DELEGATED DECISION TO DETERMINE PLANNING APPLICATIONS

Reference No:	2024/62/90326/W
Site Address:	New House Farm Cottage, Shaw Lane, Holmfirth, HD9 2PY
Description:	Erection of single storey extension
Recommending Officer:	Molly Storer

HOUSEHOLDER DELEGATED REPORT

Project: Extension		Title: Proposed Plans #	A: Extension Width reduced and doors aligned with windows
New House Farm Cottage, Holmfirth, HD9 2PZ			
Drg No: NHFC04.A			
Scale: 1:100			
Date: Jan 2024			
Status: Planning

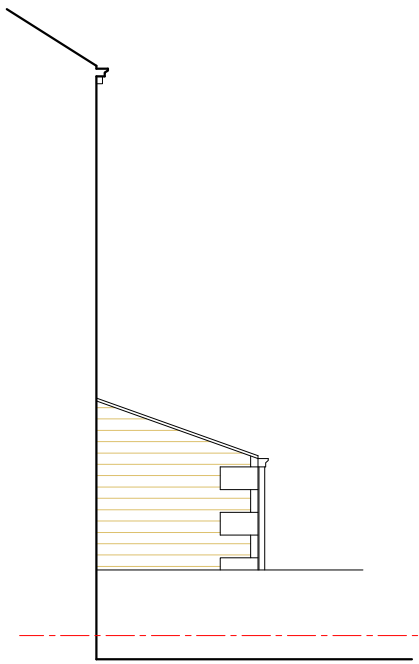
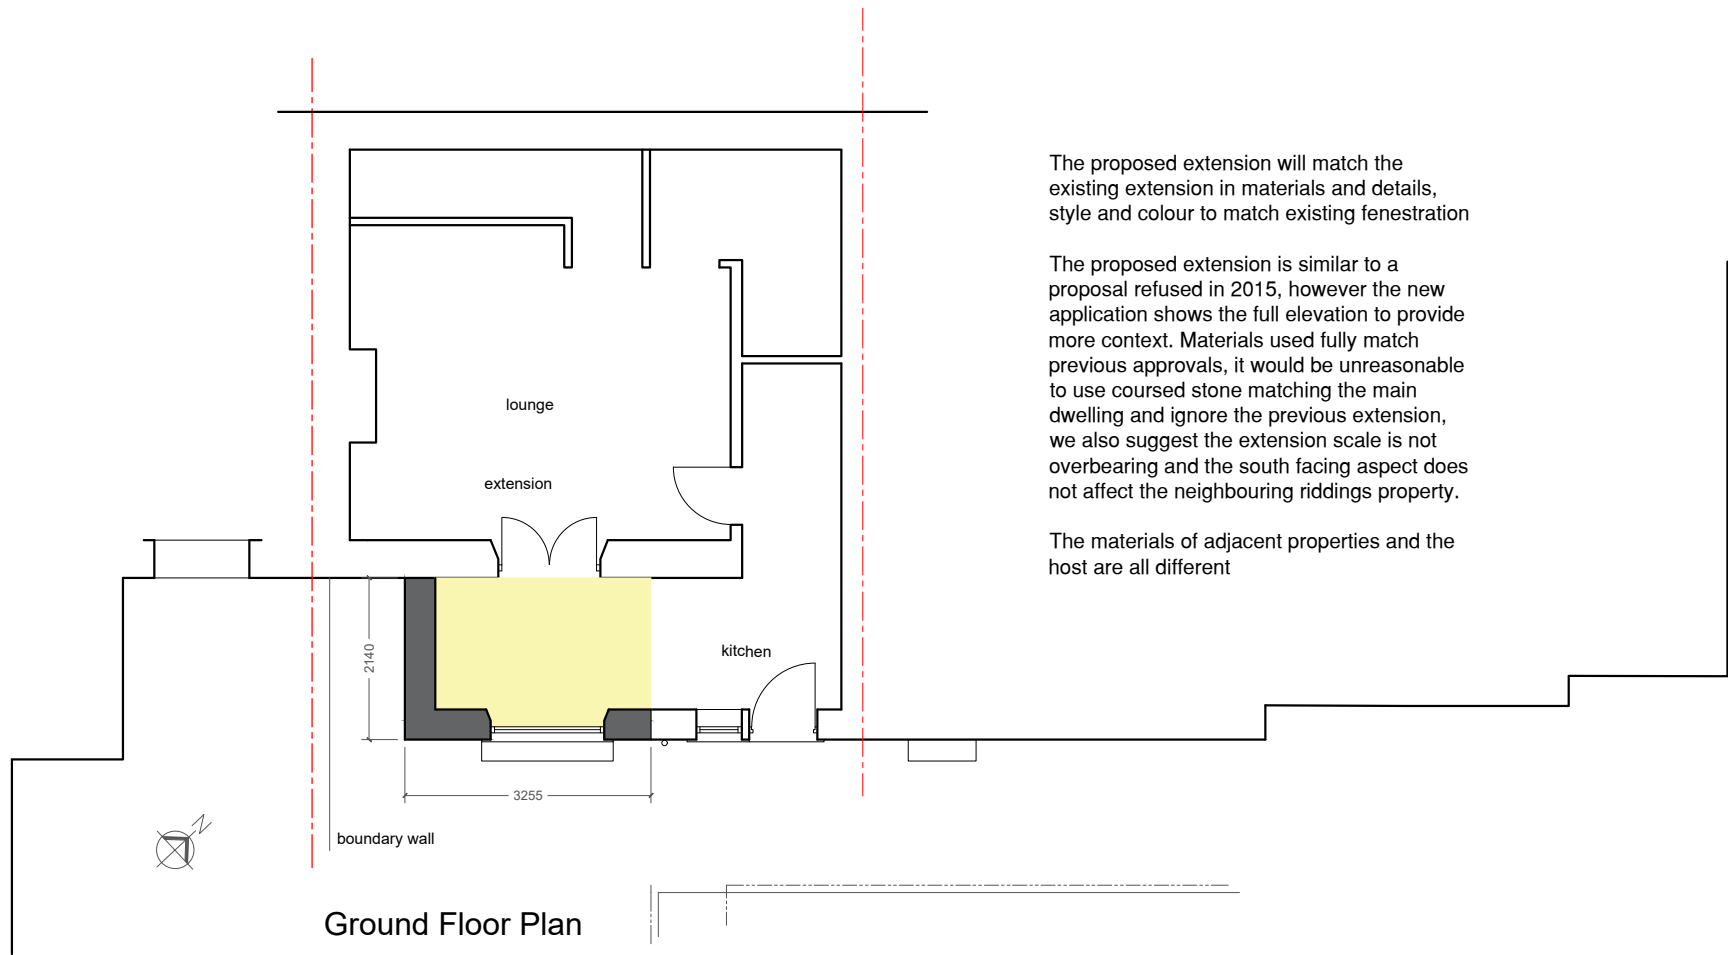
YES / NO	SUMMARY
Negotiations/Amendments during course of application	Yes	Amendments were sought due to the original plan showing that the proposal would cut the 45 degree line with the neighbouring property's ground floor window, and to ensure openings aligned. The amended plans show the extension to be built 1m off the boundary line and will not cut the 45 degree line.
Parish/Town Council comments sought	Yes (Holme Valley Parish Council)	Support
Planning History	Yes	91/04858 – Conversion from 2 flats to 2 dwellings - Conditional Full Permission. 2002/90076 – Erection of 2 storey garage building – Conditional Full Permission. 2003/92942 – Erection of two storey and single storey extensions – Conditional Full Permission. 2015/93587 - Erection of single storey front extension and raised patio – Refused. The design of the extension with a more sympathetic addition of a door to match that of the adjoining property instead of a large window as shown on the 2015 application should be noted as an amendment / improvement proposed within this application. In addition there has been a change in the policy context within which this application is required to be determined, with the adoption of the Kirklees Local Plan and also

- 2.14 metre projection from the front of the property
- 3.255 metre width
- 2.5 metres to the eaves
- 3.3 metres overall height

Height, scale and massing	• KDP 1 and 2 of the SPD • Policy LP24 Design (a), (c) and (d) of the KLP • Chapter 12 of the NPPF • Policy 1 & 2 of the HVNDP	Single storey and having limited projection (2.14m) and width which would cover less than half the width of the original dwelling and will align with the existing front extension of the adjoining property. The height of the eaves and overall height will also match that of the existing front extension. Therefore it is considered acceptable in this case.	✓
Facing materials and detailing	• KDP 9 of the SPD • Policy LP24 Design (d) (iii) of the KLP • Chapter 12 of the NPPF	Coursed stone with ashlar details for the walls and stone slate roof to match the existing property.	✓
Roof style	• KDP 1 and 2 of the SPD • Policy LP24 Design (a), (c) and (d) of the KLP • Chapter 12 of the NPPF • Policy 1 & 2 of the HVNDP	Lean-to roof design following on from the existing front extension.	✓

Window proportions	• KDP 1 and 2 of the SPD • Policy LP24 Design (a), (c) and (d) of the KLP • Chapter 12 of the NPPF • Policy 1 & 2 of the HVNDP	There will be bifolding doors on the southeast facing front elevation which will replace large, full length windows which exist on this elevation. There will also be two roof lights within the roof slope of this elevation.	✓
Accessibility for all users	• KDP 17 of the SPD • Policy LP24 Design (f)	Private domestic extension – no alterations to general access arrangements	✓

Relevant key design principle (KDP) of the SPD, Policy in the Kirklees Local Plan and the NPPF	Further comments	✓ / X / N/A
Impact on privacy of neighbours (to sides, rear and front)	• KDP 3 & 4 of the SPD • Policy LP24 Design (d) (iv)	There will be no windows located in the southwest elevation which faces onto The Ridings therefore it is considered	✓

• Chapter 12 of the NPPF • Policy 2 of the HVNDP	that privacy to this property will not be affected.	
Impact on light and outlook of neighbours (to sides, rear and front)	• KDP 4, 5, 6 of the SPD • Policy LP24 Design (b) • Chapter 12 of the NPPF • Policy 2 of the HVNDP	Amended plans show that the extension will retain a gap of 1m to the boundary. As a result of the amendments put forward the 45 degree line is not intersected from the centre of the cill or worse meaning the the neighbours ground floor habitable window will not be significantly affected. In regard to overshadowing due to the orientation of the properties, the neighbouring dwelling will experience some shadowing during the early morning of the summer months however this is not considered to be significant in this case. It is therefore considered that there will not be a significant impact upon the amenity of neighbouring occupiers in this regard.	✓
